## Heckington Fen Solar Park

EN010123

### Appendix 16 Statutory Consultation – Written Responses under Section 42 of the Act & How Ecotricity responded

Document Reference: 5.1.16

Drawing file: EN010123 / EN010123-000201-6.2.4 - Figure 4.1c Proposed Solar PV Development Areas.pdf

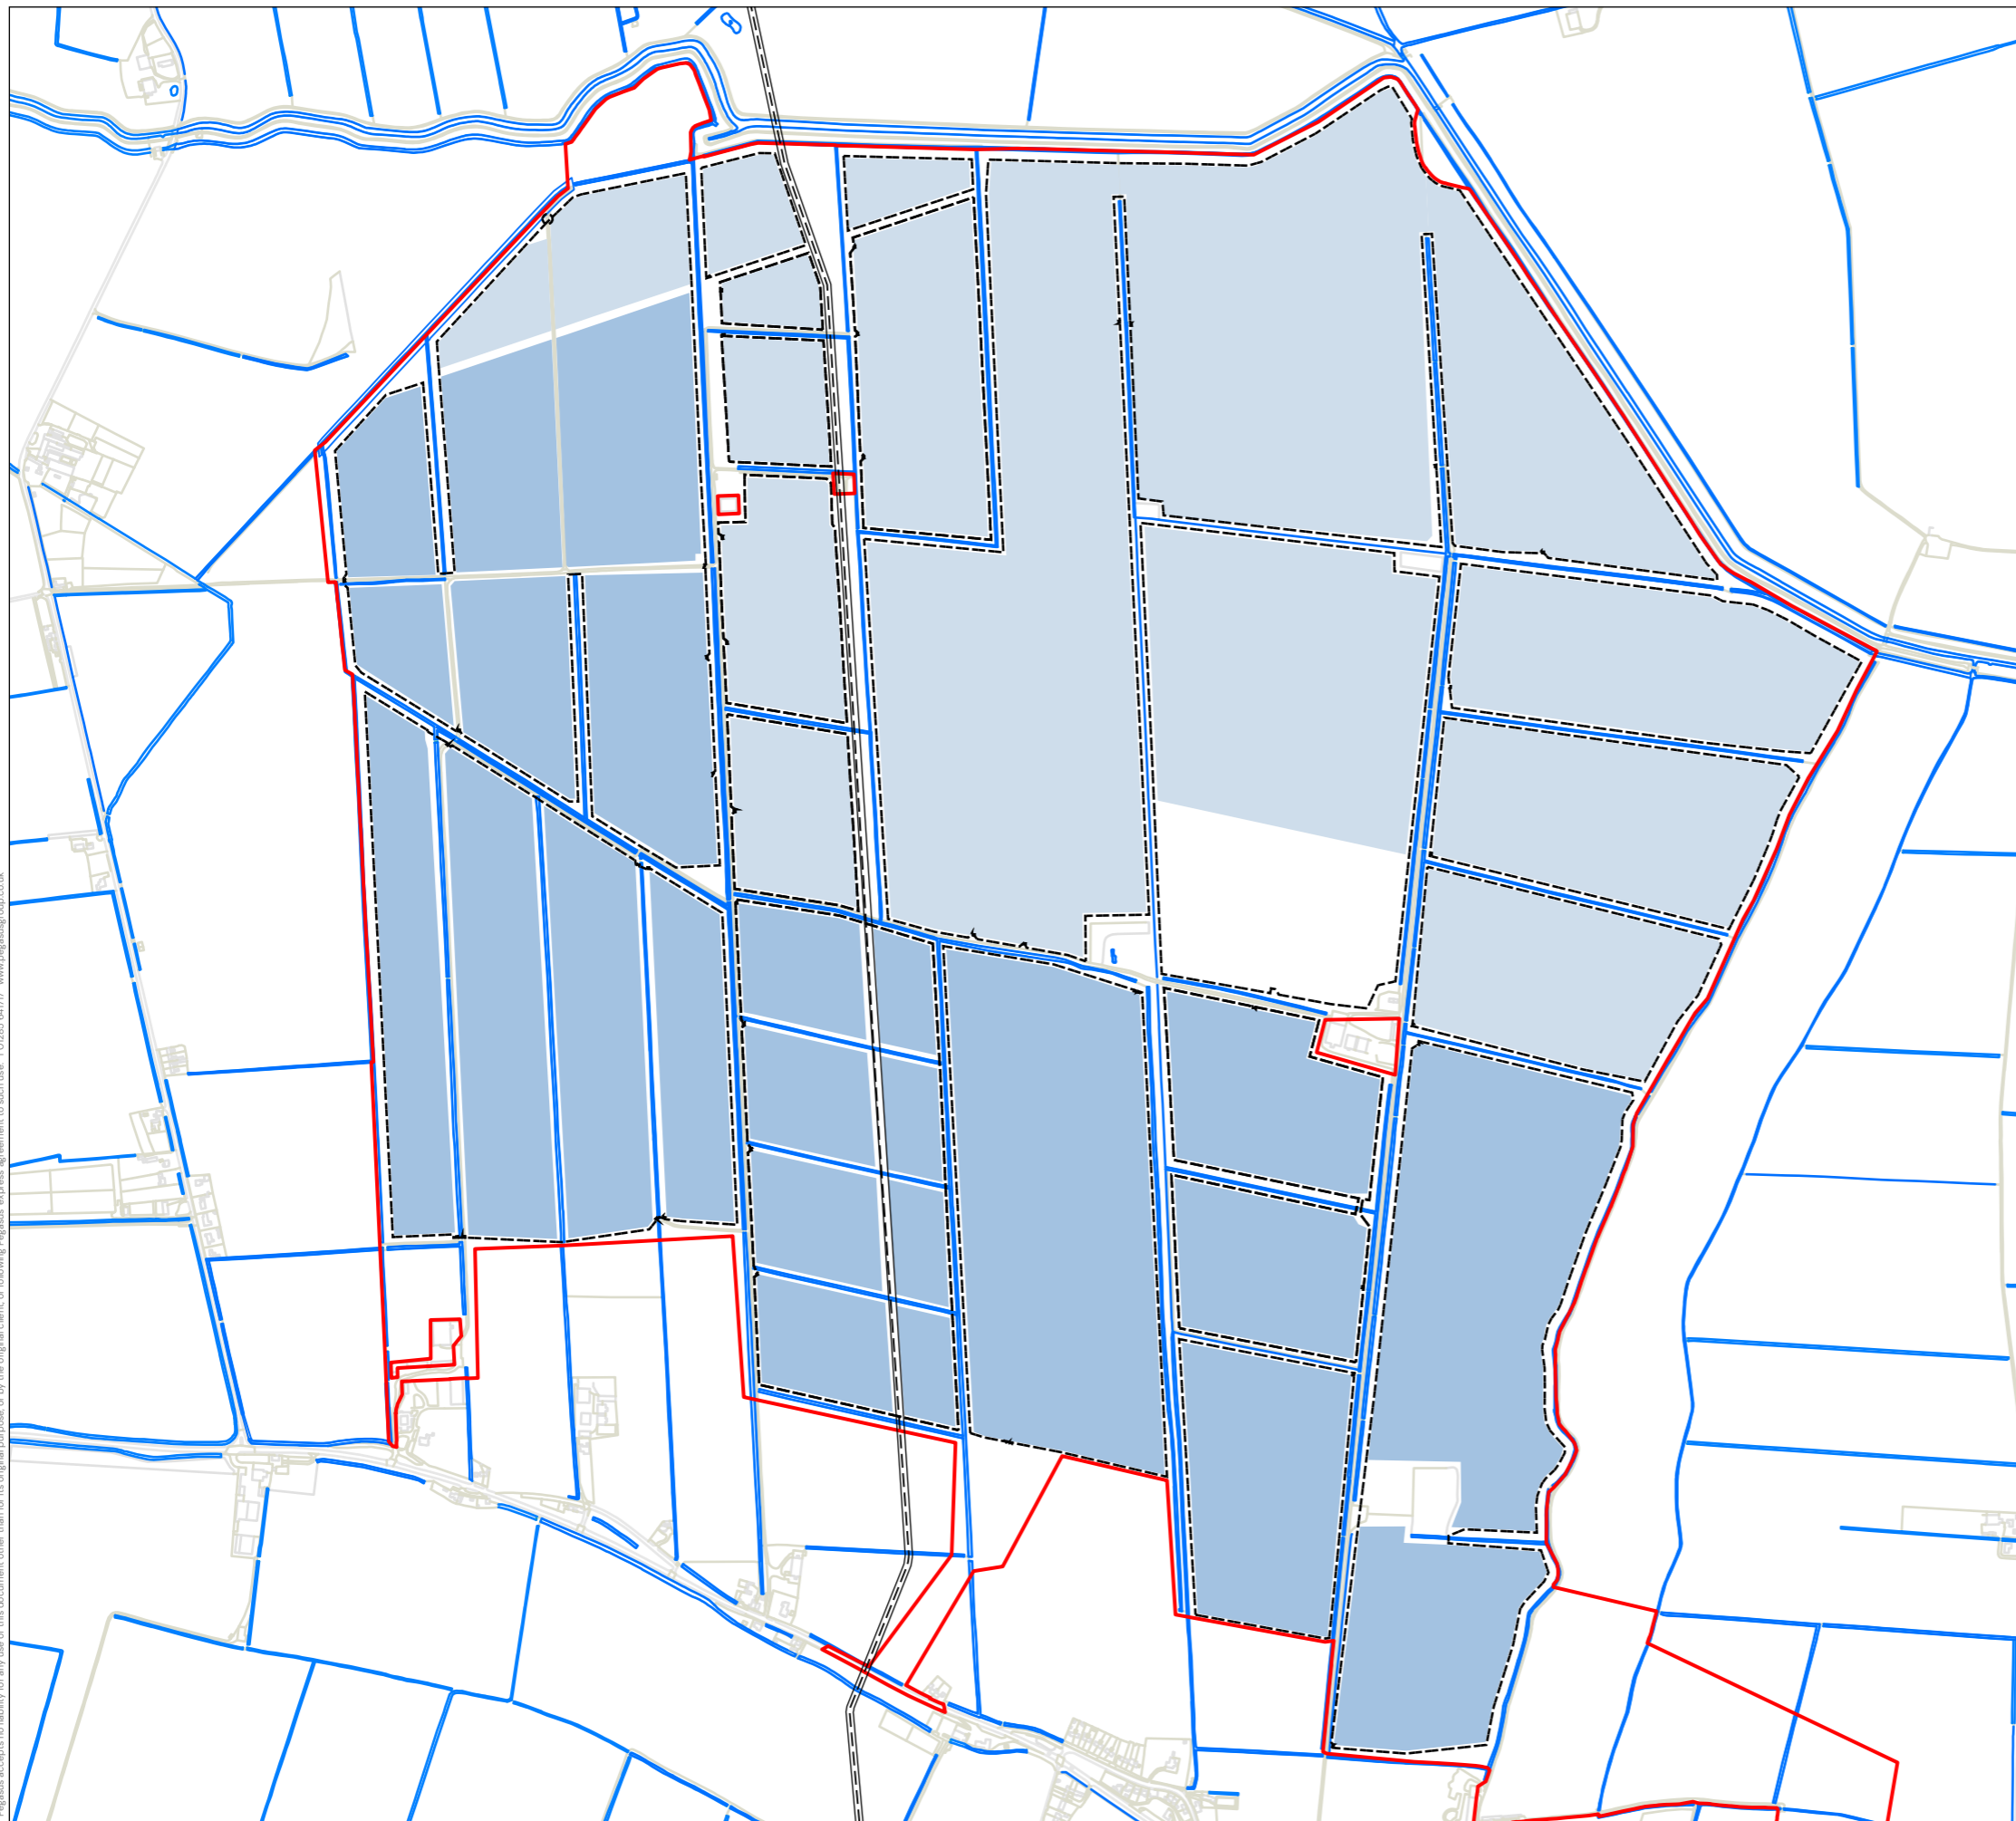
Issue Topic	Consultee	Date	Stakeholder Comment	Regard had by the Applicant
			offsets provided on Figure 4.1 C and seek opportunities for positive contributions to the landscape of the site. We would recommend an Outline Landscape and/or Ecological Management Plan, or similar, be developed to provide a clear strategy to secure any mitigation and enhancement areas.	and Ecological Management Plan is provided with the DCO (document reference: 7.8).
Chapter 5, Planning policy	Environment Agency	16 August 2022	Under the Environmental Permitting (England and Wales) Regulations 2016, permission must be obtained from the Environment Agency for any proposed activities which will take place: <ul style="list-style-type: none"> <li>· in, over, under or within 8 metres of a main river (16 metres if tidal)</li> <li>· on or within 8 metres of a flood defence structure or culvert (16 metres if tidal)</li> <li>· on or within 16 metres of a sea defence</li> <li>· within 16 metres of any main river, flood defence (including a remote defence) or culvert for quarrying or excavation</li> <li>· in a flood plain more than 8 metres from the river bank, culvert or flood defence structure (16 metres if tidal) having the potential to divert flood flows to third parties, if planning permission has not already been granted for the works</li> </ul>	The Applicant notes this comment.

Drawing file: EN010123 / EN010123-000202-6.2.4 - Figure 4.1d Proposed Energy Storage System and New Infrastructure.pdf

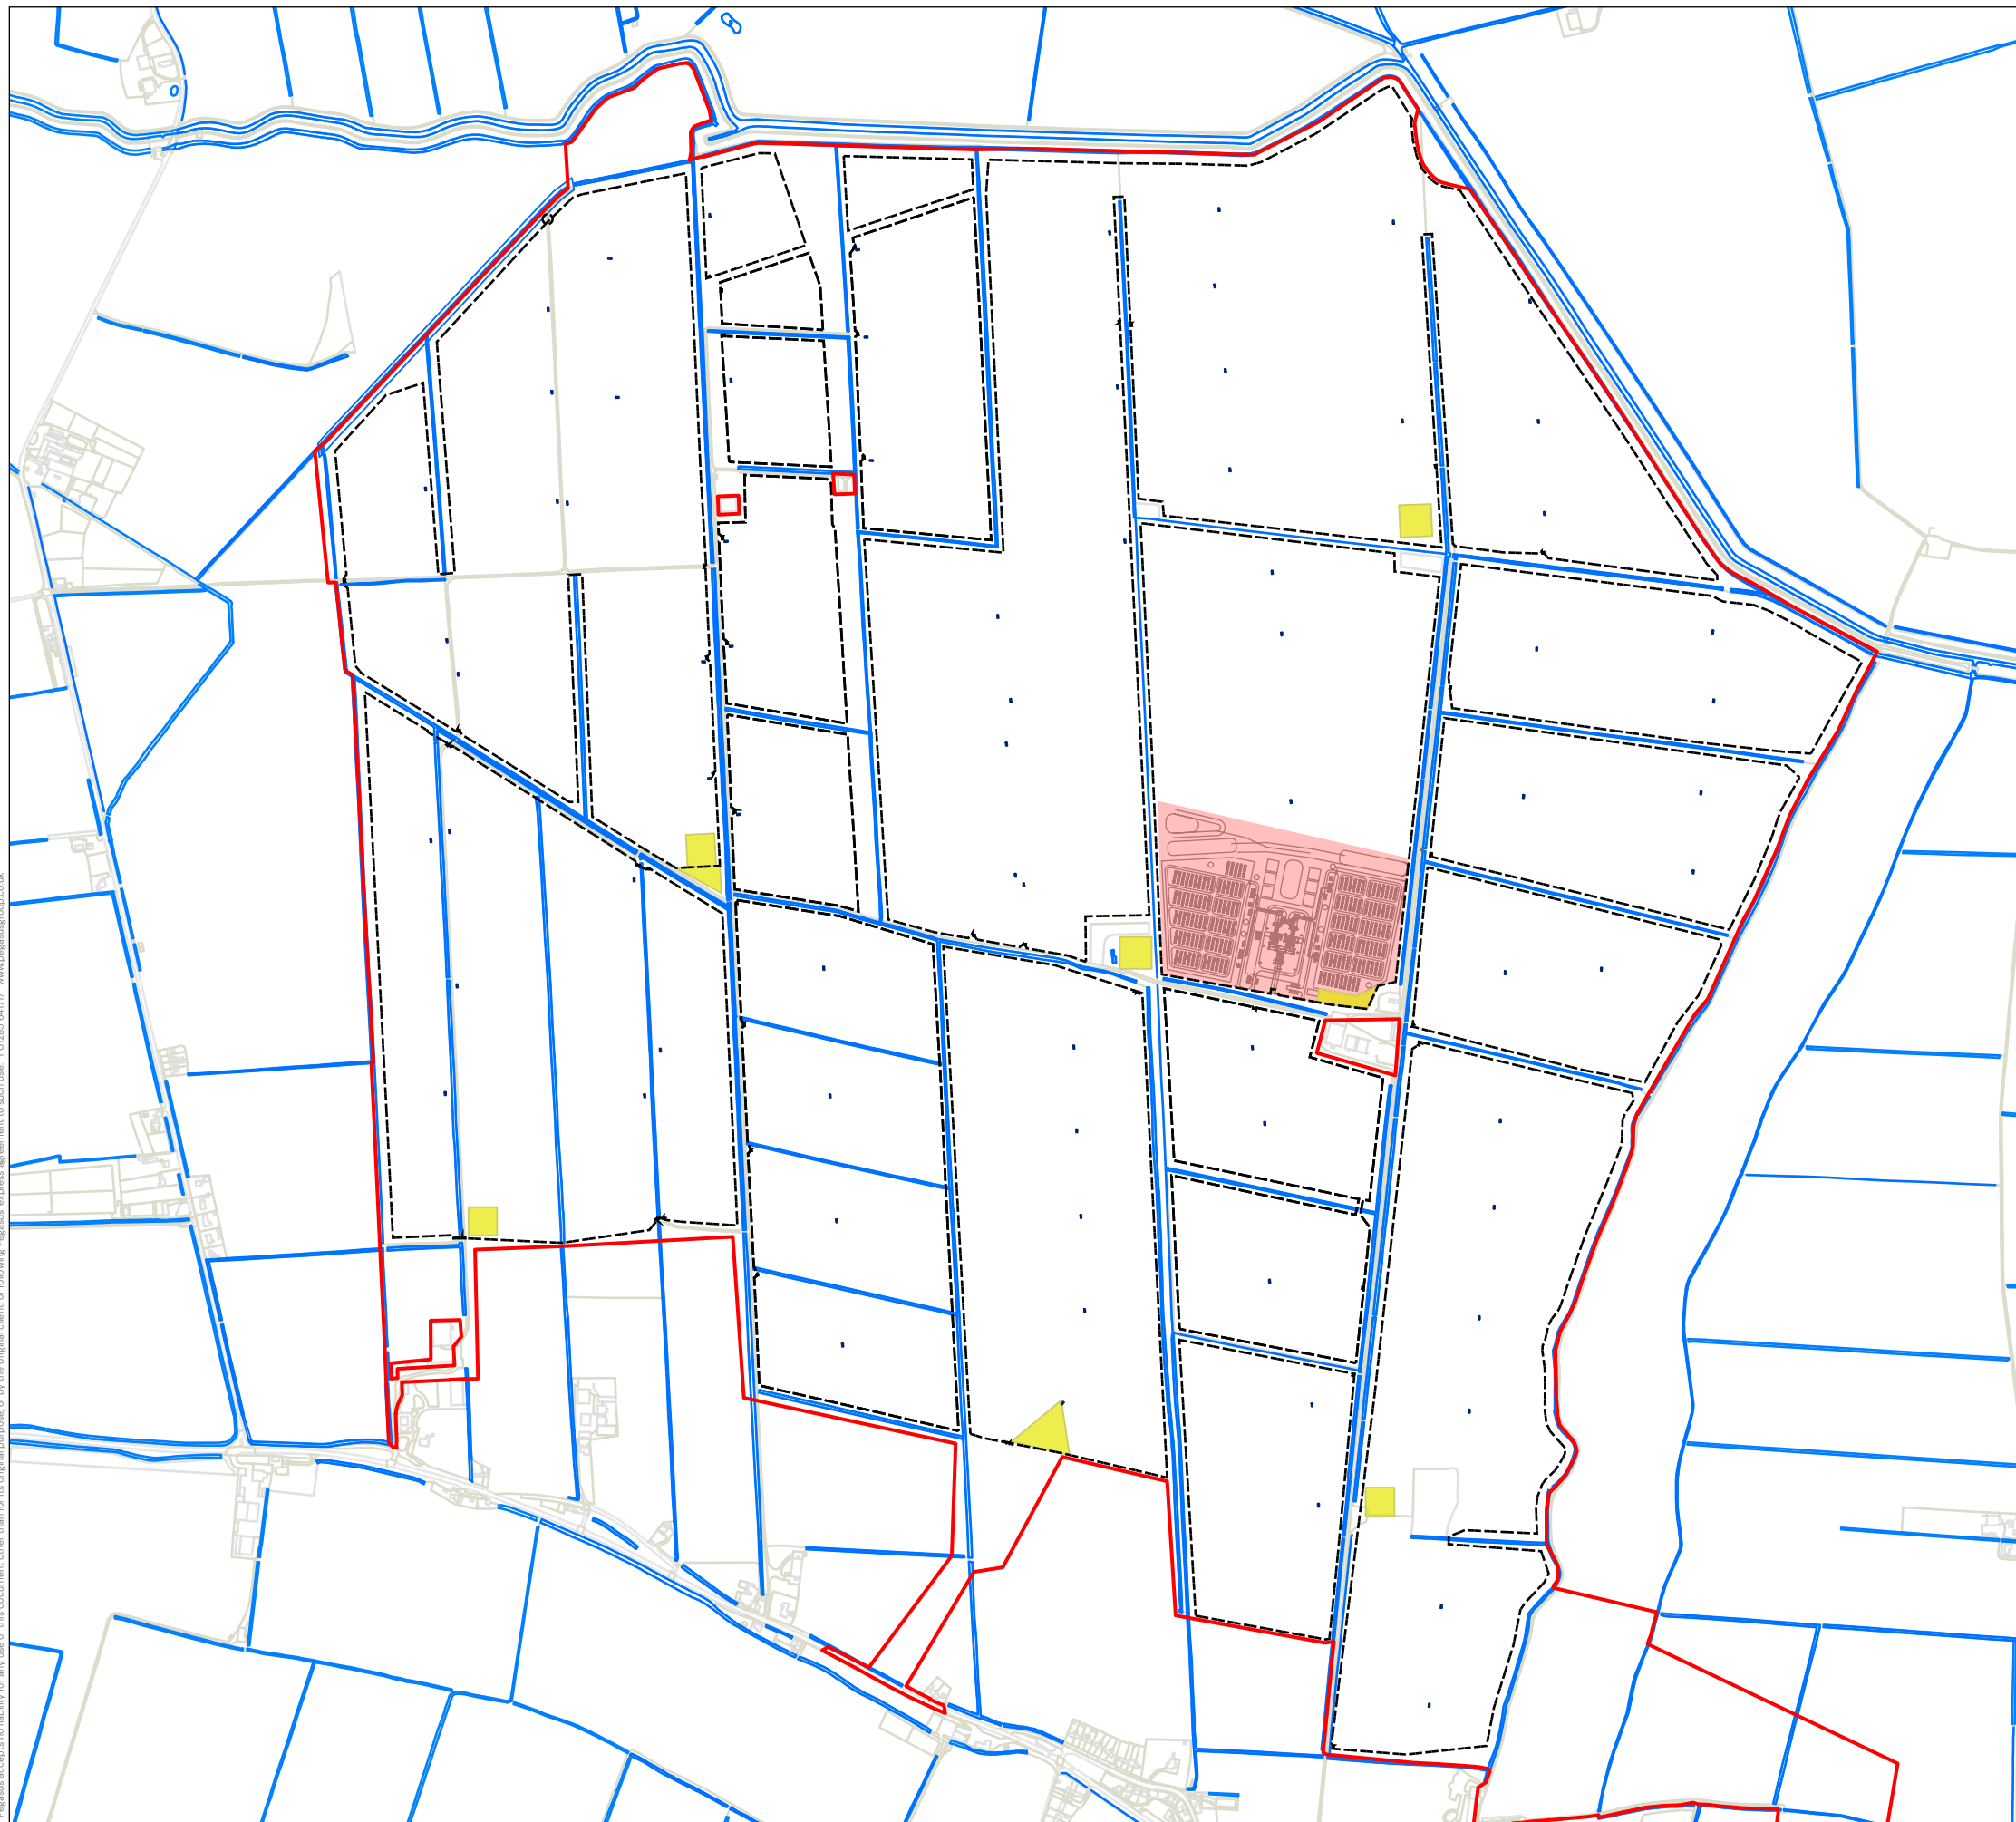
Chapter 4, Proposed Development	North Kesteven District Council	1 September 2022	<u>Fig 3.2</u> Figure 3.2 (Working Indicative Site Layout) and Figure 4.1d (Proposed Battery Storage and New Infrastructure) identify significantly different sized areas for the battery storage area. This should be clarified to ensure consistency across all plans and layouts used to inform the assessments carried out as part of the ES (also see comments under 'Noise and Vibration' section). Figure 3.2 (Working Indicative Site	The Applicant notes this comment. Figure 3.2 was a working layout for information, 4.1d reflected the layout in the PEIR (and was therefore correct) at

Chapter 4, Proposed Development	Lincolnshire County Council	6 September 2022	<ul style="list-style-type: none"> <li>Figure 3.2 (Working Indicative Site Layout) and Figure 4.1d (Proposed Battery Storage and New Infrastructure) identify significantly different sized areas for the battery storage area. This needs to be clarified to ensure consistency across all plans and layouts used to inform the assessments carried out as</li> </ul>	<p>The Applicant notes this comment. There is a single area on the Energy Park site for the ESS. This is a design alteration from the PEIR which</p>
